# CITY OF ALBUQUERQUE

December 12, 2017

**RE: Country Club Plaza Bldg 3  
Drainage Report and Conceptual Grading and Drainage Plan  
Engineers Stamp Date: 12/8/17  
Hydrology File: J13D010**

*Country Club Plaza III*  
*Drainage Management Plan*

PROJECT Country Club Plaza | Building 3
1716 Central Avenue SW
Albuquerque, NM 87104
TITLE CONCEPTUAL GRADING & DRAINAGE PLAN

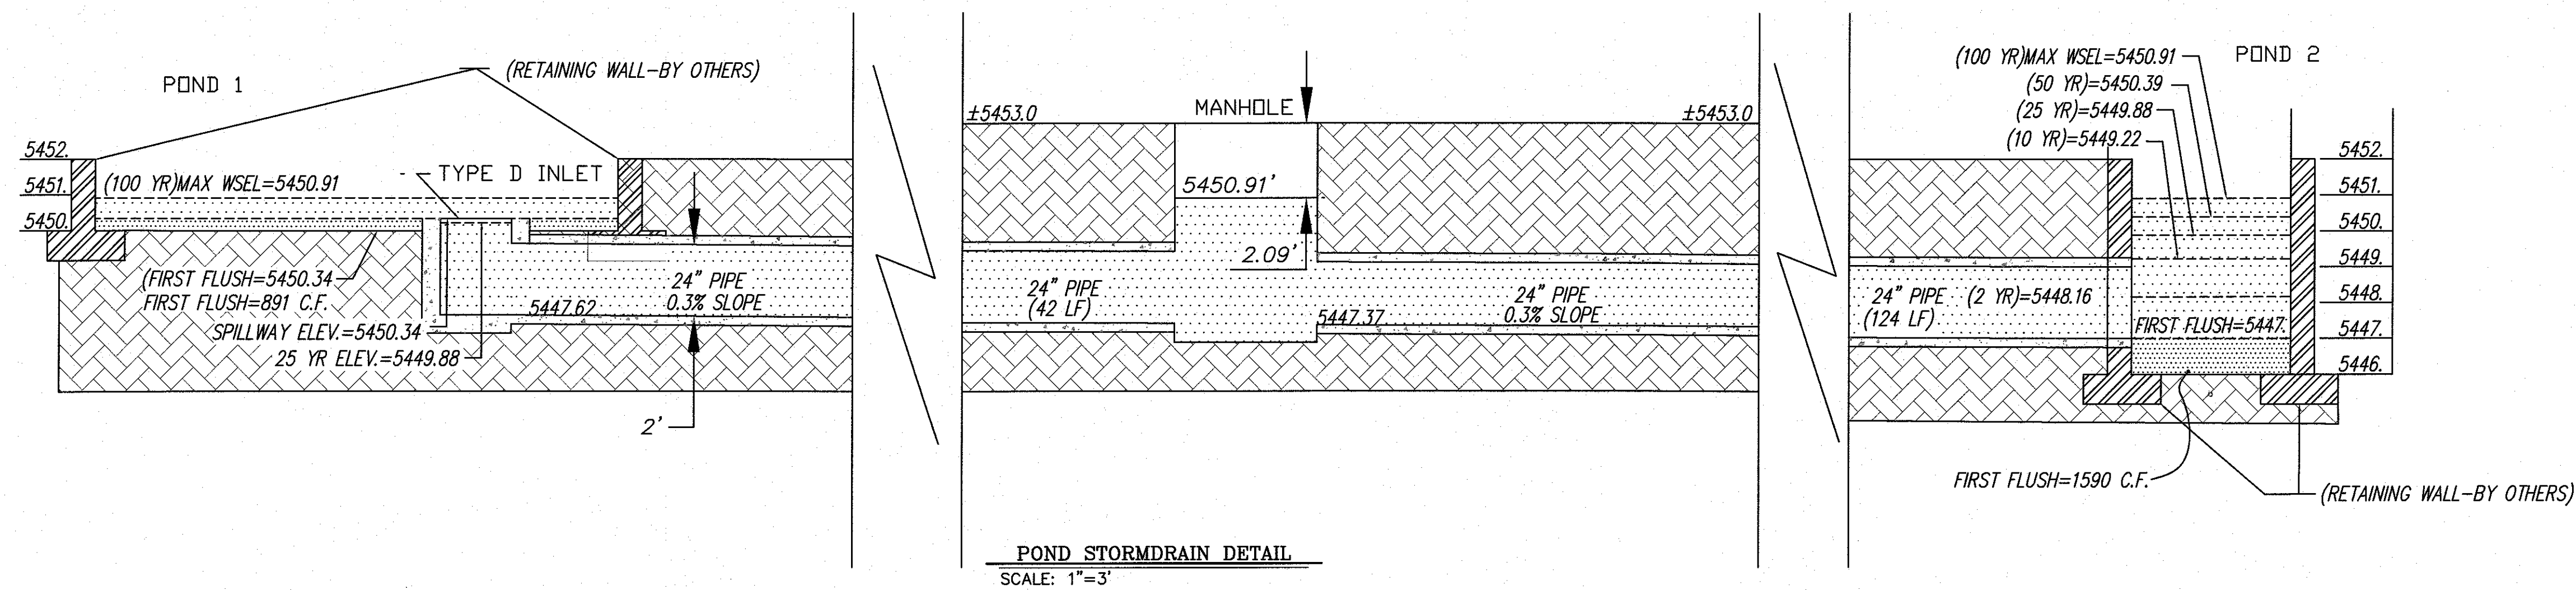
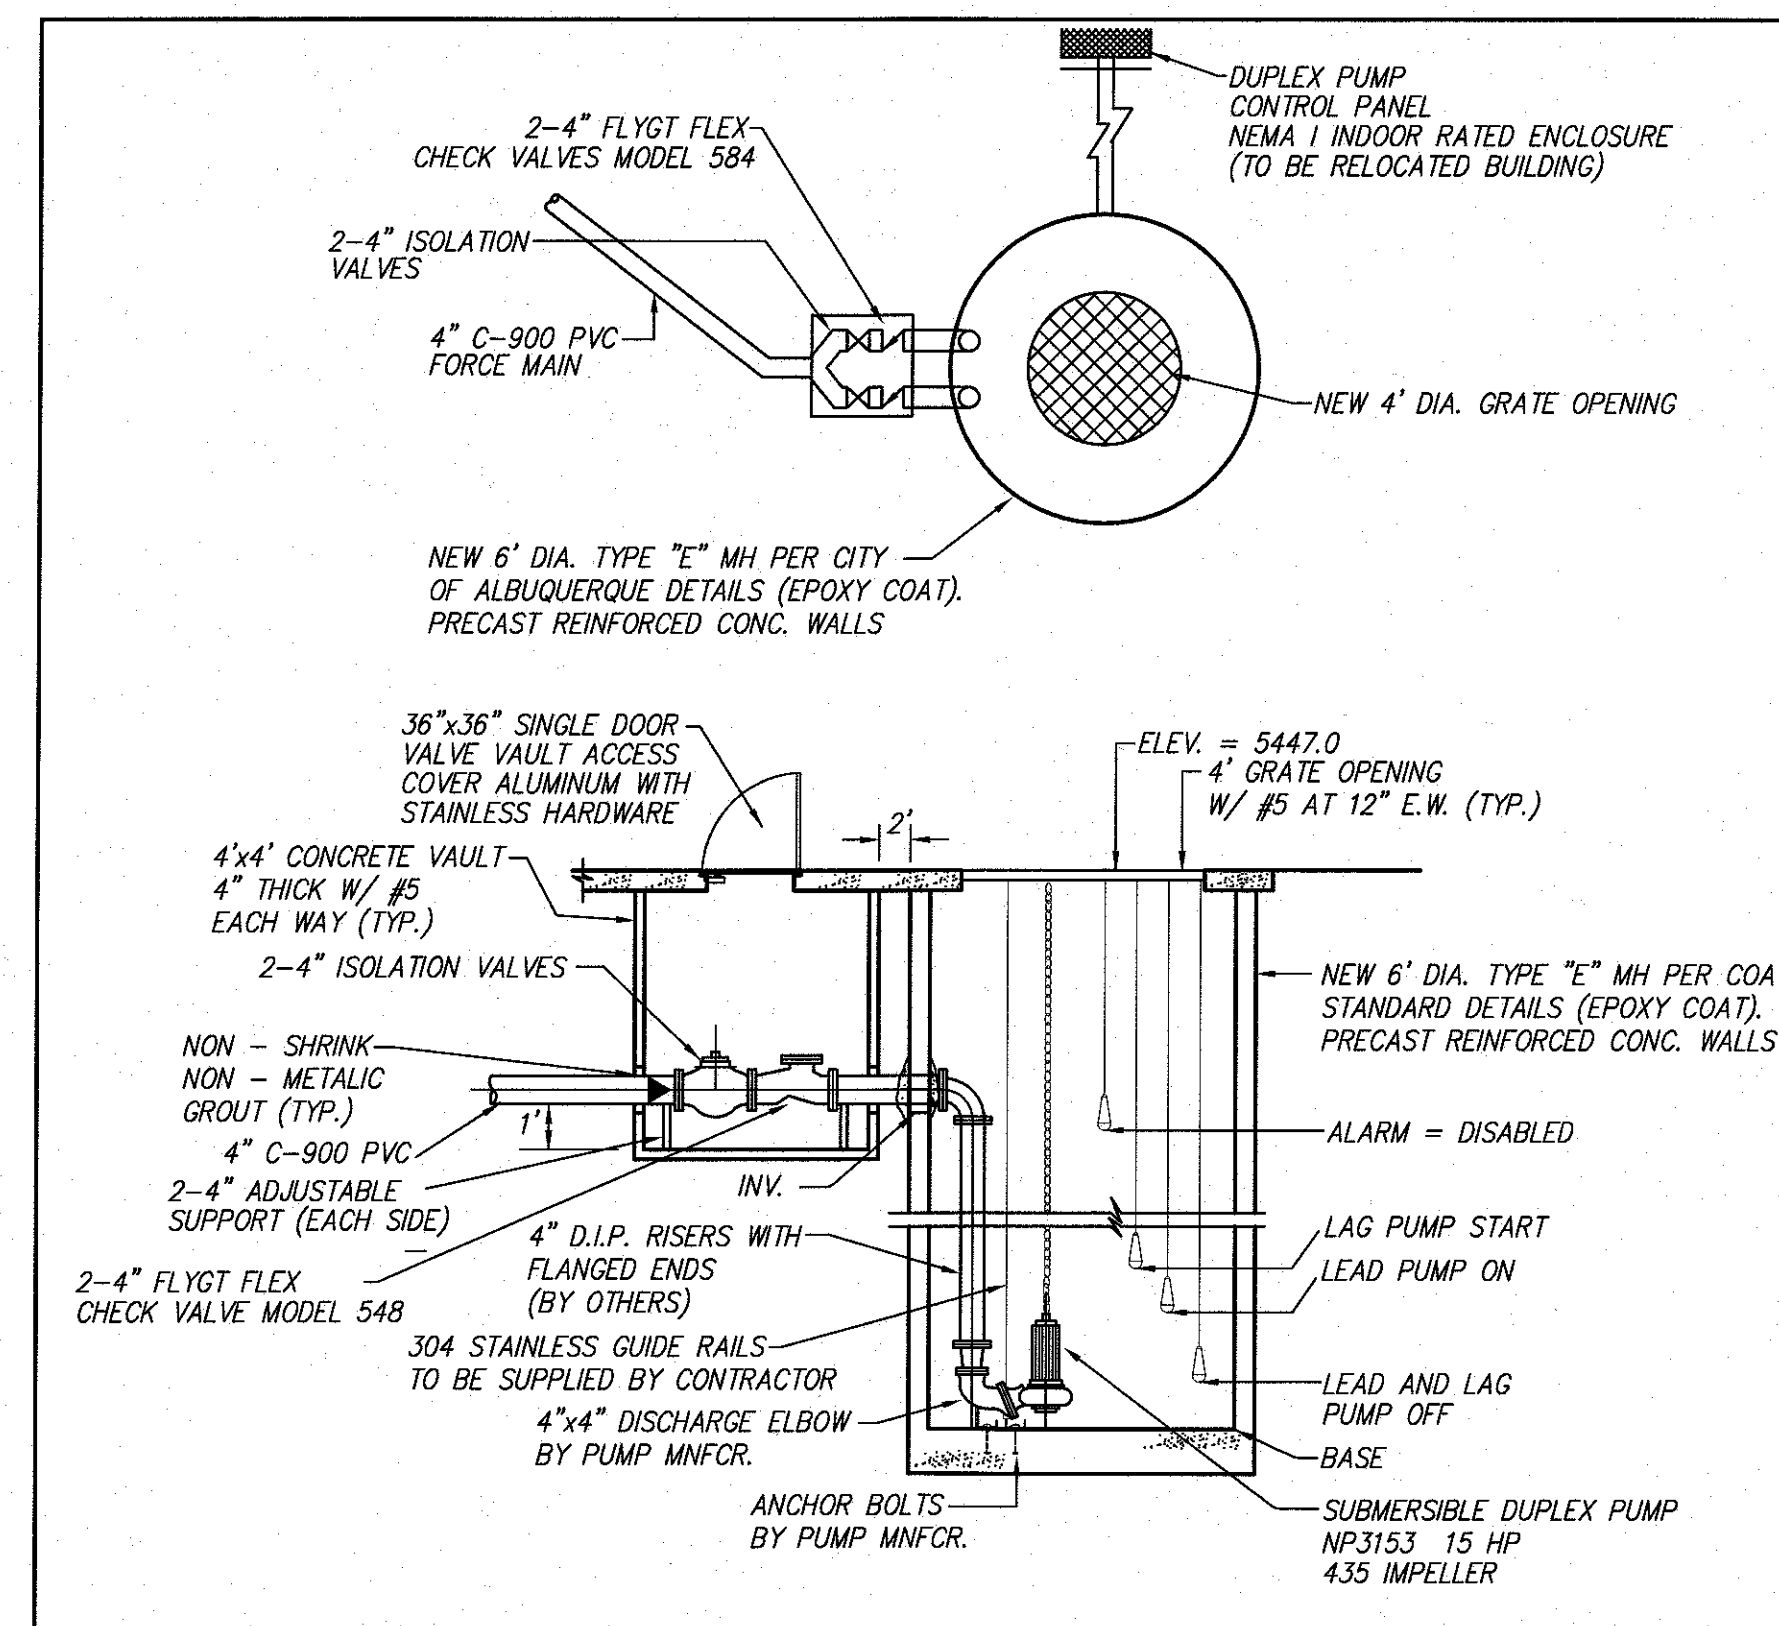
1. Demonstrate that if the pump fails, the 100-year, 10-day volume will not flood the adjacent properties. i.e.: determine this water surface elevation and show that it will either remain on the Country Club Plaza property or flow overland out to Laguna. Provide section views across the property line as required to support this.

1. The 100-year 10-day storm event analysis has been added in Appendix B,
2. A short explanation about the analysis has been added to main text for 'developed conditions,
3. Text about "paring the existing wall" to elevation 4953.0 along the SW property line has been added to the G&D Plan

Both pond volumes were calculated to an elevation of 4953.0' and then the limits at elevation 4953.0 were determined and then the total volume provided with this scenario were determined and compared to the actual calculated runoff volume. The volume provided is greater than the volume calculated for the 100 year 10 day storm event.

This plan proposes a shallow (3.6") flat swale that extends from Pond #2 to Laguna Blvd. This invert of the swale is dictated by the existing flowline in Laguna Blvd. The survey indicates this elevation to be 4952.70'. This will at least allow for runoff to be directed to Laguna in the event of a failure. This is the best that can be provided for a spillway to Laguna Blvd.
